NSW RURAL FIRE SERVICE

Your Ref: MP 07_0026 MOD 7
Our Ref: DA-2017-05411-S4.55-1

23 July 2020

Lot 5 DP 1239938, Montwood Drive, Lennox Head – MP 07_0026 MOD 7

**EPIQ ESTATE - SUPER LOT 5
LOT LAYOUT**
CLIENT: CLARENCE PROPERTY
LOCATION: LOT 5 DP1239938
CNR SNAPPER DRIVE AND MONTWOOD DRIVE
LENNOX HEAD, NSW, 2478
DATE: 26.06.2020
SCALE: 1:1000 @ A3
DRAWN: D. YOUNG
REF: 14351-S5-IN-PL-01

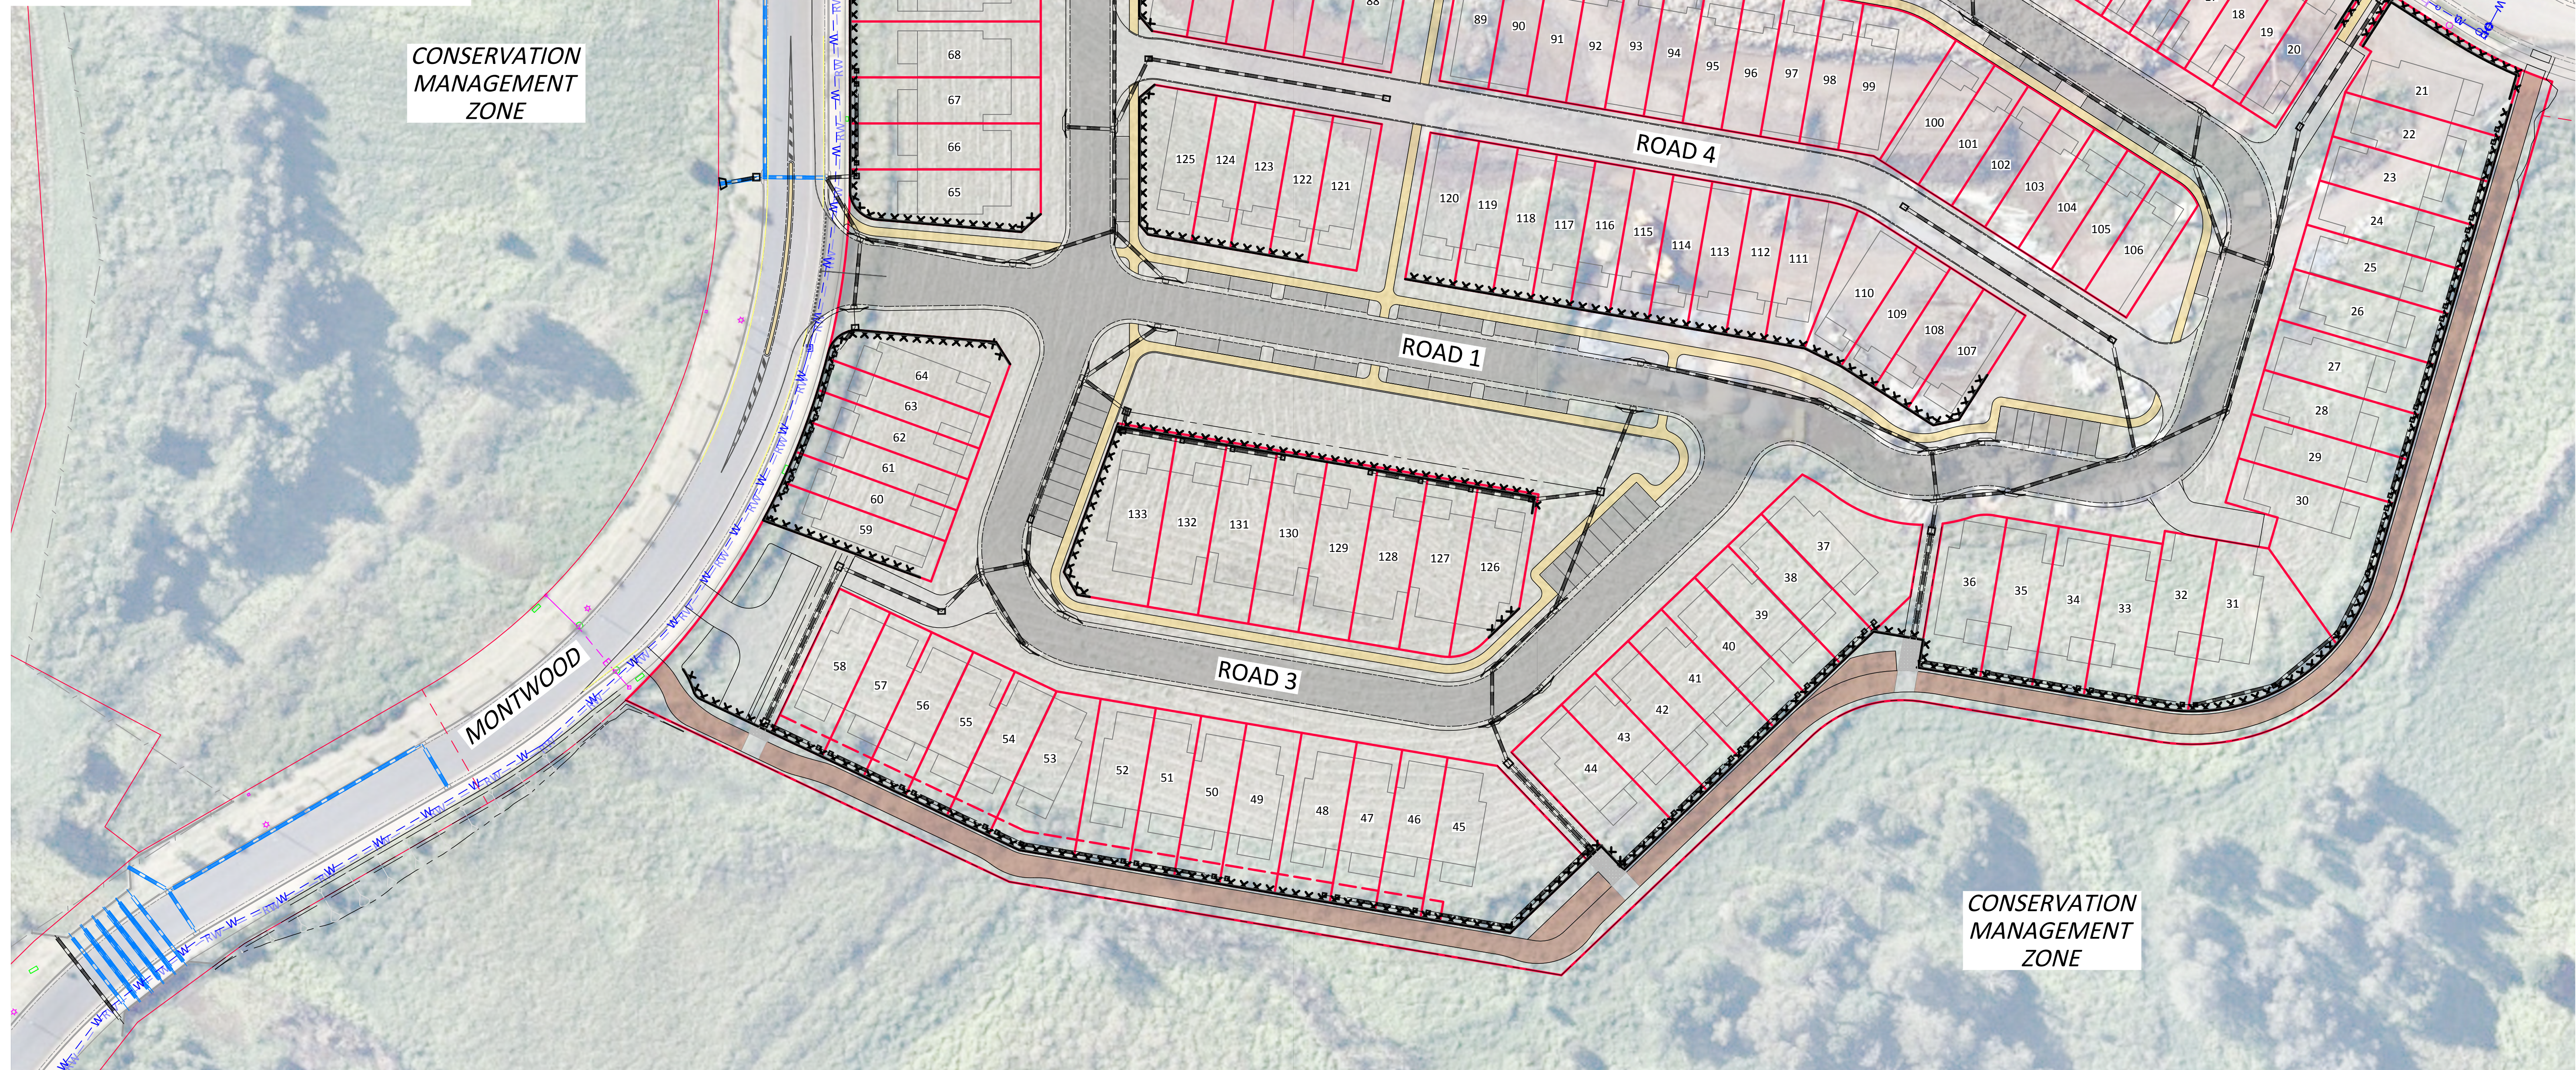
1. At the issue of a subdivision certificate, and in perpetuity to ensure ongoing protection from the impact of bush fires, the entire area of the proposed residential lots and the full 5 metre width of the access track adjacent to the Conservation Management Zone must be managed as an inner protection area (IPA). The IPA must comprise:
 - minimal fine fuel at ground level;

4. Public roads must comply with of section 4.1.3 (1) of 'Planning for Bush Fire Protection 2006'.
5. The access track adjacent to the Conservation Management Zone must include:
 - a minimum carriageway width of 4 metres;
 - a minimum vertical clearance of 4 metres to any overhanging obstructions, including tree branches;
 - a minimum trafficable width of 6 metres at the maintenance bays to provide an area for vehicles to pass;
 - any gates, bollards or similar being provided with a key / lock system authorised by the local NSW RFS.
